**KIRKLEES METROPOLITAN COUNCIL
INVESTMENT & REGENERATION SERVICE**

Reference No: 2021/62/93254/W

Site Address: 52, Virginia Road, Marsh, Huddersfield, HD3 4AZ

Description: Erection of single storey rear and two storey side extension

PROPOSED FIRST FLOOR PLAN

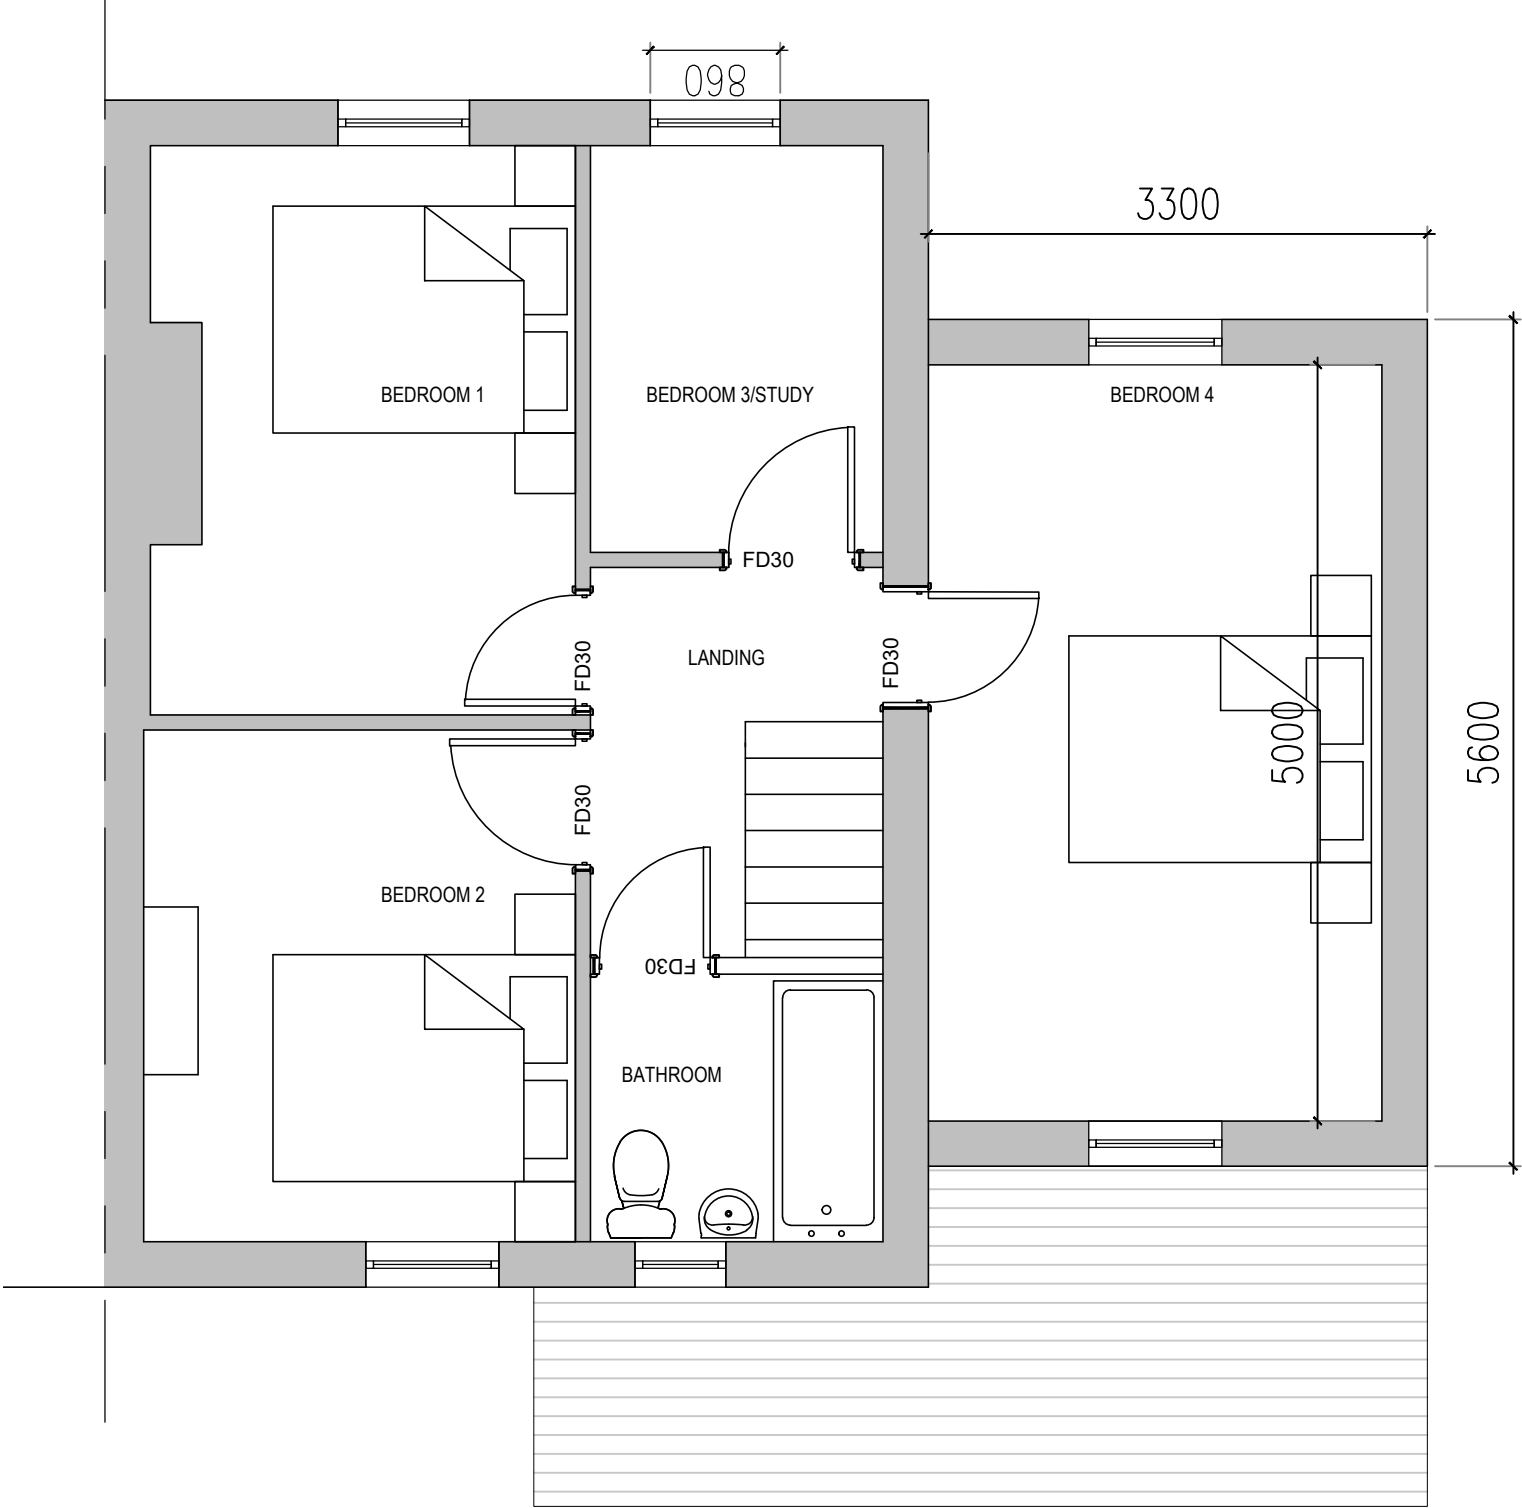
- Plans – Shared shed is not visible on proposed and is visible on the proposed rear elevation. An objection was raised on the removal of this shed.

Officer Note: Plans correspond with each other, the shed is to be demolished on No. 52's side. This is a private matter and not a planning consideration. A footnote has been attached for clarity.
